**REQUEST**

Current Zoning: R-3 LWPA (single-family residential, Lake Wylie Protected Area)  
Proposed Zoning: MX-2(CD) LWPA (mixed use, conditional, Lake Wylie Protected Area)

Approximately ~~22.87~~ 23.15 acres located on the north side of Oakdale Road between Miranda Road and Interstate 485.

The petition proposes to allow up to 138 duplex townhouse style attached residential dwelling units at a density of 6 dwelling units per acre on parcels that are developed with single-family homes and a former golf clubhouse.

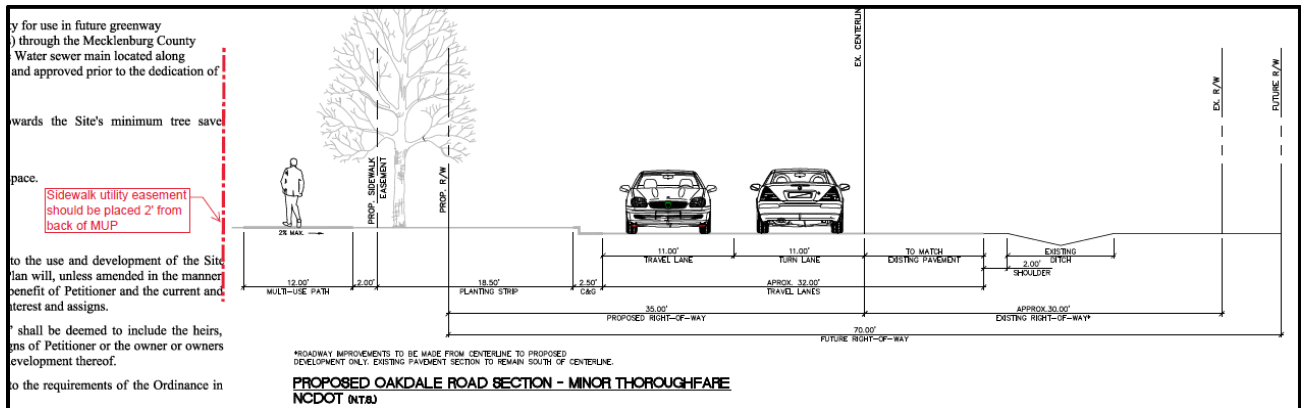
1. ~~The petitioner should revise the proposed Oakdale Road cross section to relocate the multi-use path (MUP) sidewalk easement to 2 feet from back of MUP.~~ **Addressed**
2. ~~The petitioner should revise the site plan and conditional note(s) to clarify that the proposed access below will be reviewed and considered by NCDOT, during plan permitting, as either full movement or right in/right out. A right in/right out access will only be permitted if a center median is installed. If full movement, NCDOT may require the storage and taper length of the Oakdale Road left turn lane to be extended. A detailed review will be completed during permitting.~~ **Addressed**
